Sent: 15 February 2012 17:54
To: Planning
Subject: Planning application S6/2011/2594/FP - 87 De Havilland Close

Response to Planning application from Hertfordshire County Council (T and CP GDP Order 1995)

Location
87 De Havilland Close
Hatfield

Proposal
Dwelling house to 5 bed House of Multiple Occupation, independent bedsit and single storey rear extension and outbuilding

87 DE HAVILLAND CLOSE, BLOCK PLAN
SCALE: 1:500

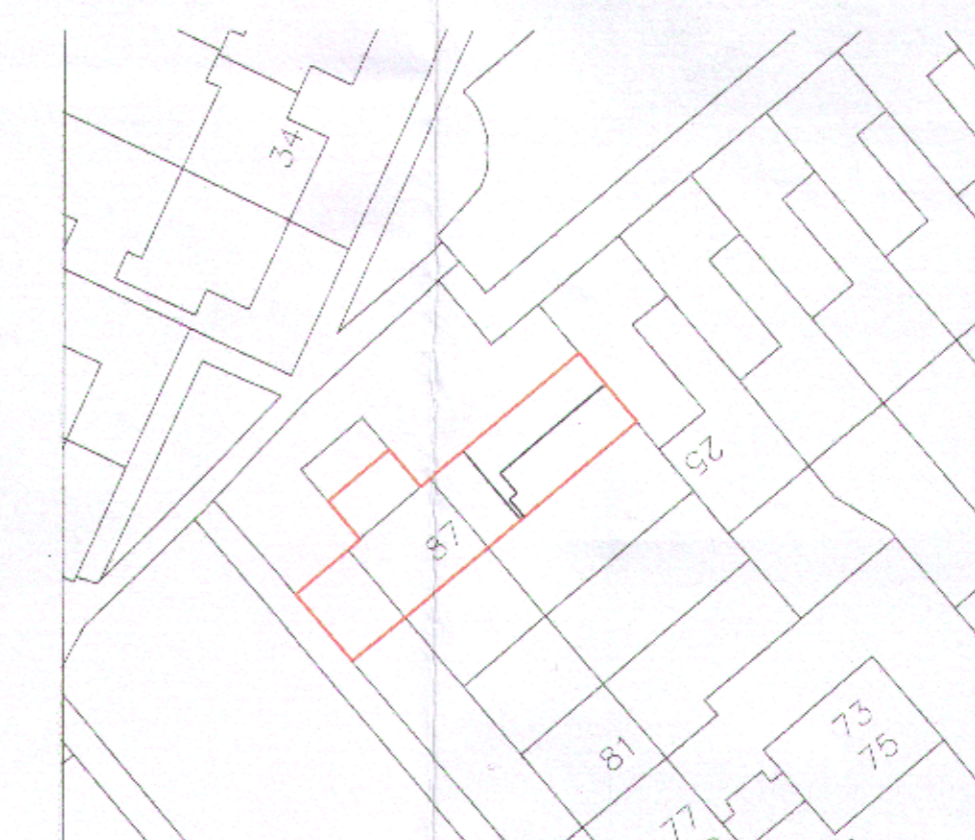
This is a retrospective application for change of use of a dwelling to 4 bed House of Multiple Occupation, independent bedsit and single storey rear extension and outbuilding. The existing garage has been converted to a bedsit. The application form states there is one parking space which I assume is on the driveway serving the property however no details are provided and I would recommend that if planning permission is granted a parking layout should be provided. The proposed change of use increases the parking requirement according to the WHBC and it should be noted that in the Houses in Multiple Occupation SPD (February 2012) the car parking provision for HMO's is considered a minimum rather than maximum. However it would be difficult for the highway authority to sustain at objection to a shortfall of 1 or 2 parking spaces on a residential road on the grounds of highway safety and free flow.

- 1. C8.12 - The area set aside for car parking shall be laid out and surfaced, in accordance with a scheme which has been submitted to and agreed in writing by the local planning authority before the buildings hereby permitted are first occupied and shall be retained permanently there after for the accommodation of occupiers and shall not be used for any other purpose.
